REQUEST

The petition proposes to allow for the redevelopment and expansion of the existing Panthers’ Practice Facilities and associated accessory uses.

Panthers Stadium, LLC and City of Charlotte

Panthers Stadium, LLC

SHEET TITLE
PEDESTRIAN CONNECTION
 SHEET NUMBER
RZ-5.0

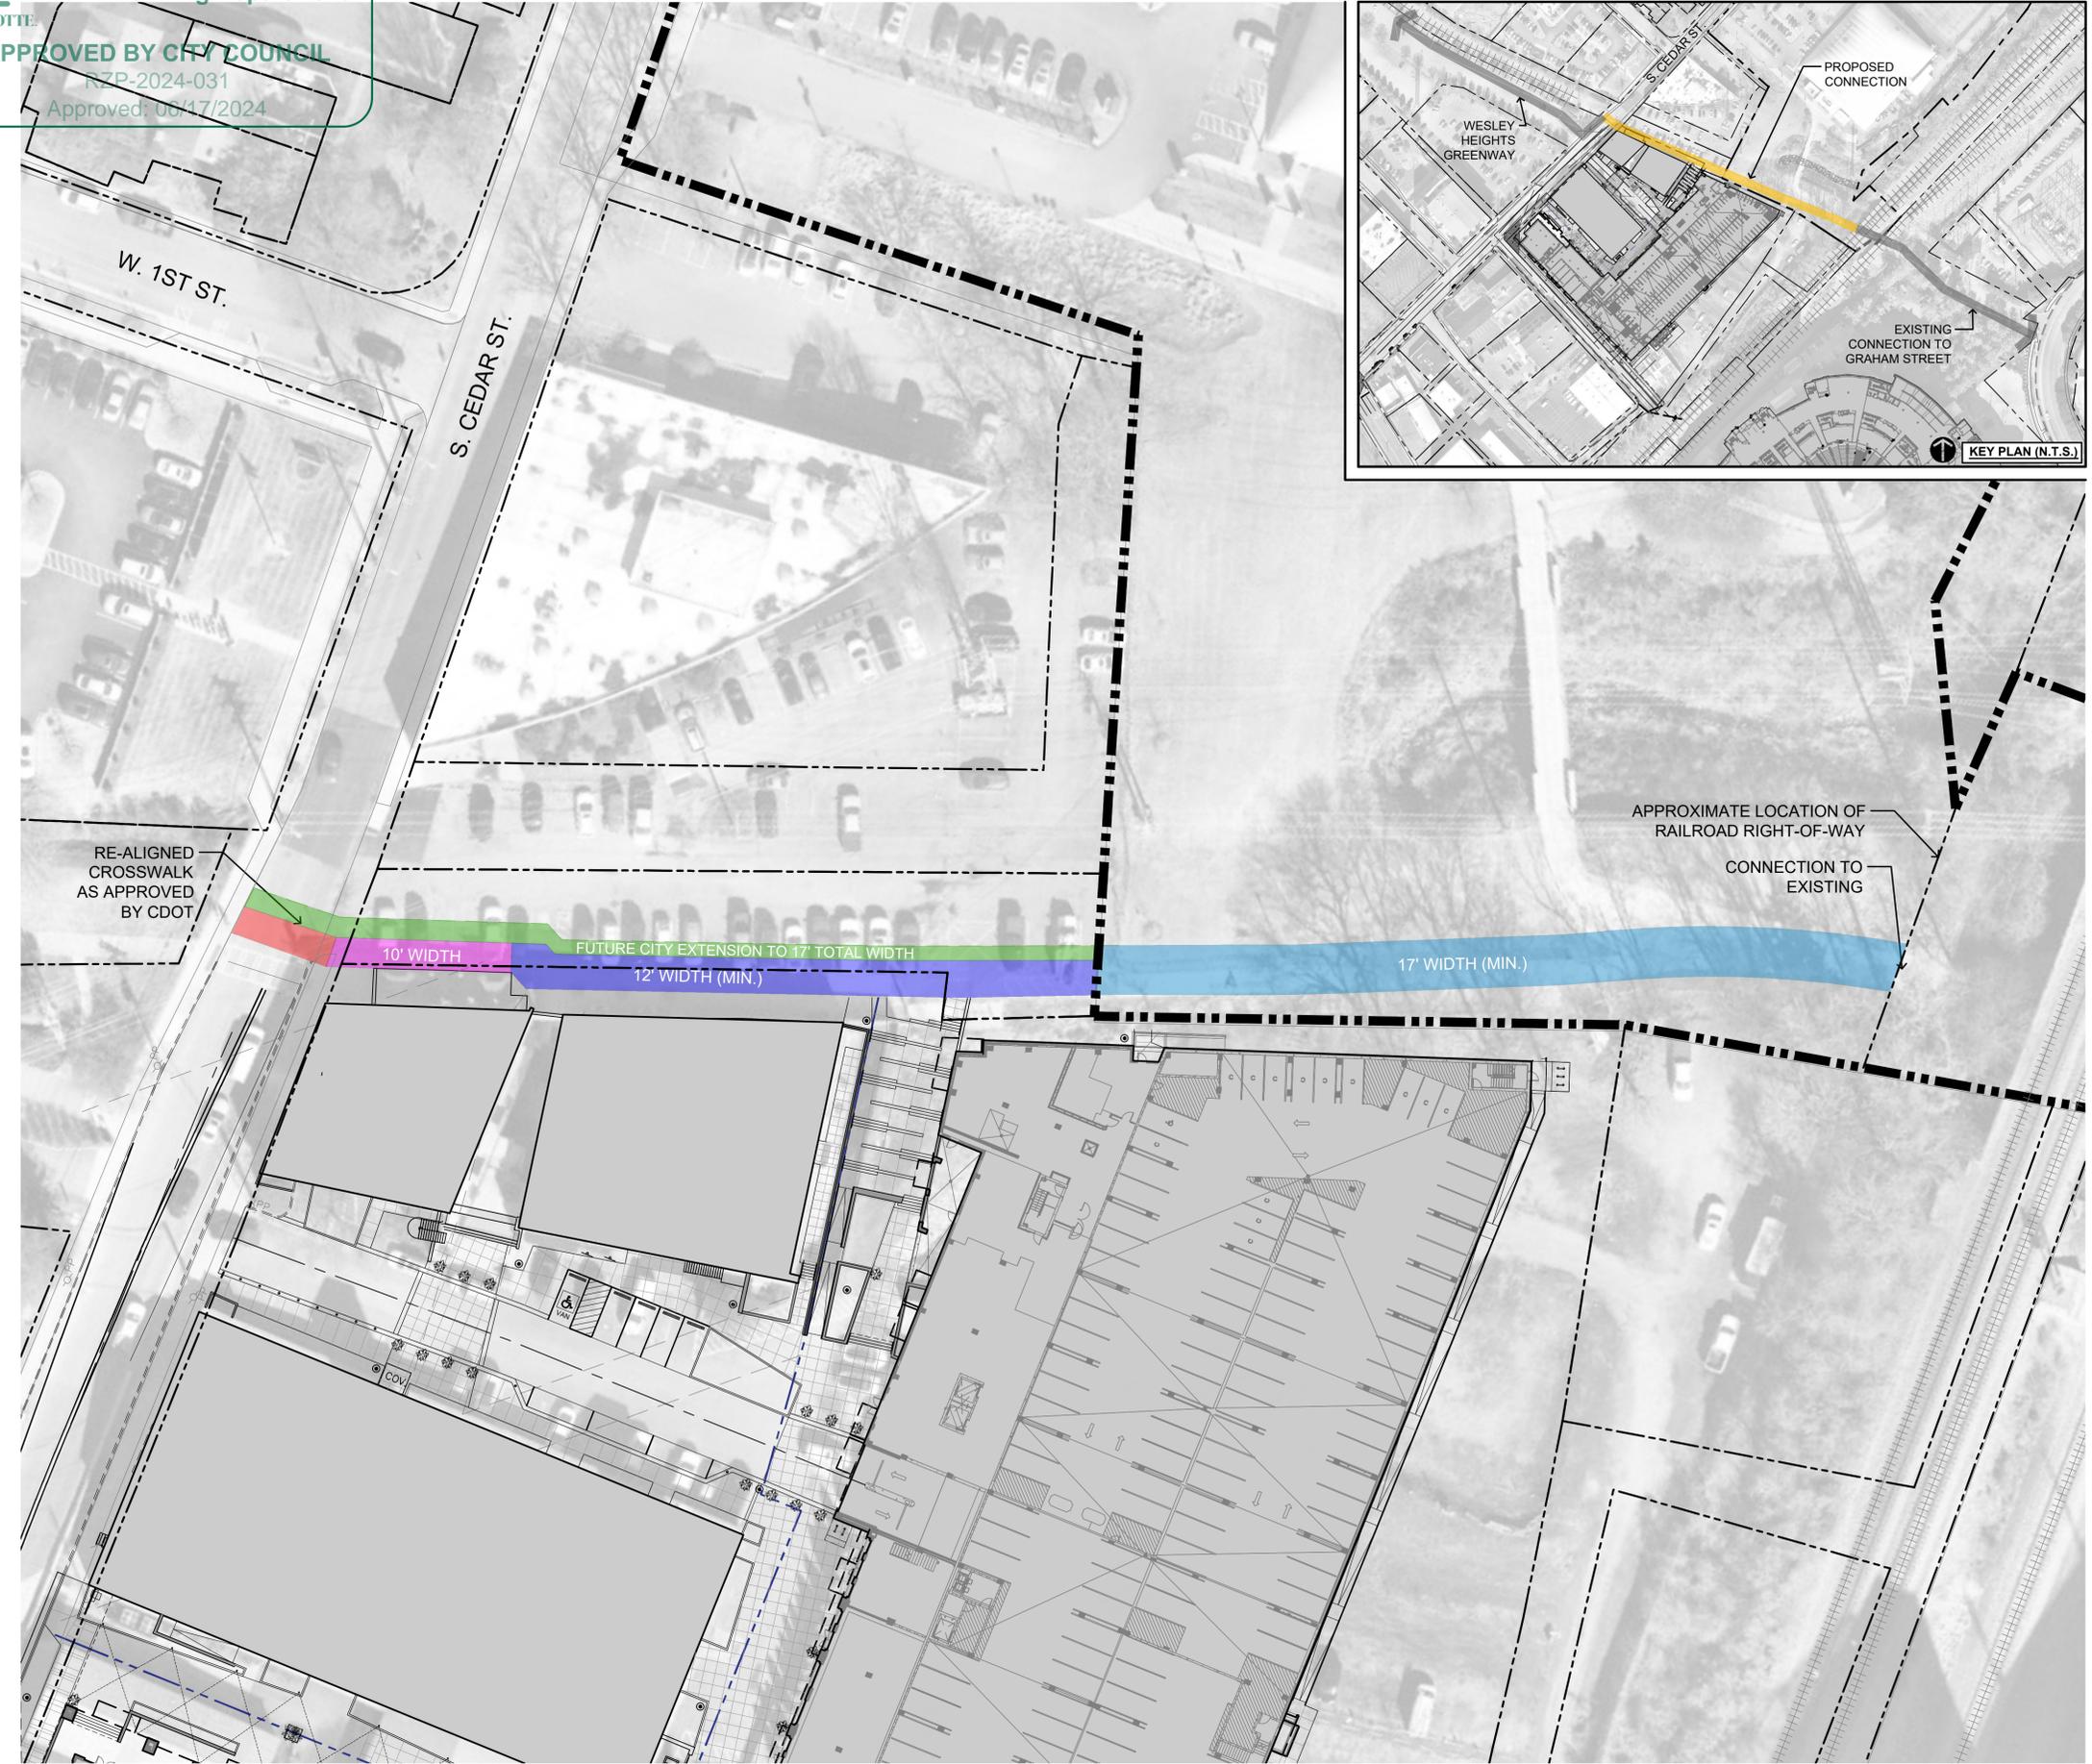
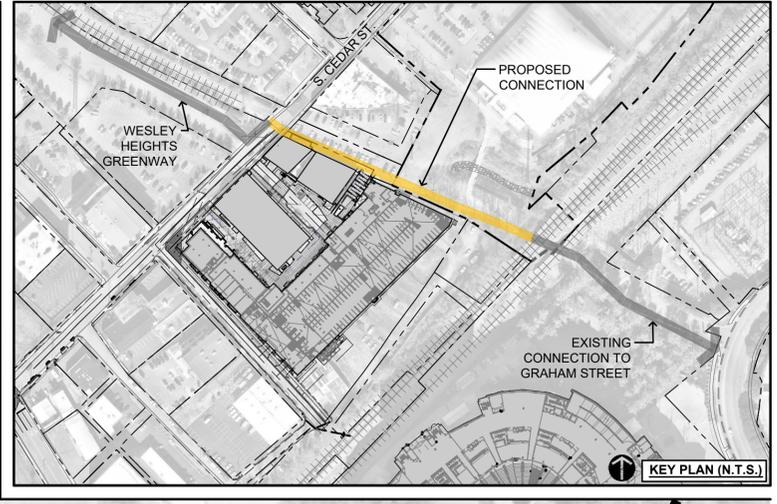
- ~~20. Revise the conditional notes on the pedestrian pathway to note that what is being proposed is the reconstruction and improvement of the existing pathway to a 12' shared use path. Add notes on any additional improvements such as lighting or signage. Indicate that public access to the path will function similarly to current operations. **Addressed**~~

- **As depicted on the site plan, a pedestrian shared-use path connection shall be provided on the site to provide a linkage from the existing Irwin Creek Greenway to the tunnel near Graham Street. The petitioner will collaborate with the City and AP Foundry to provide an uninterrupted pedestrian path connecting Cedar Street across portions of the City parcel and the AP parcel.**

- **The connection shall include a continuous 17' wide concrete paved surface for the portion of the path that is located within this rezoning boundary. The path will be 12' wide across portions of the City parcel, and 10' wide for a small portion of the path directly abutting Cedar Street. The City may seek to widen the pedestrian connection along the proposed 12' and 10' portions of the path to 17' in connection with Cycle Track improvements.**

- **This path shall not have stairs, except those that are ADA compliant, and shall include wheel stops where necessary. Lighting and wayfinding signage may be provided if needed. The path shall remain open for continuous public use subject only to required maintenance and repair**
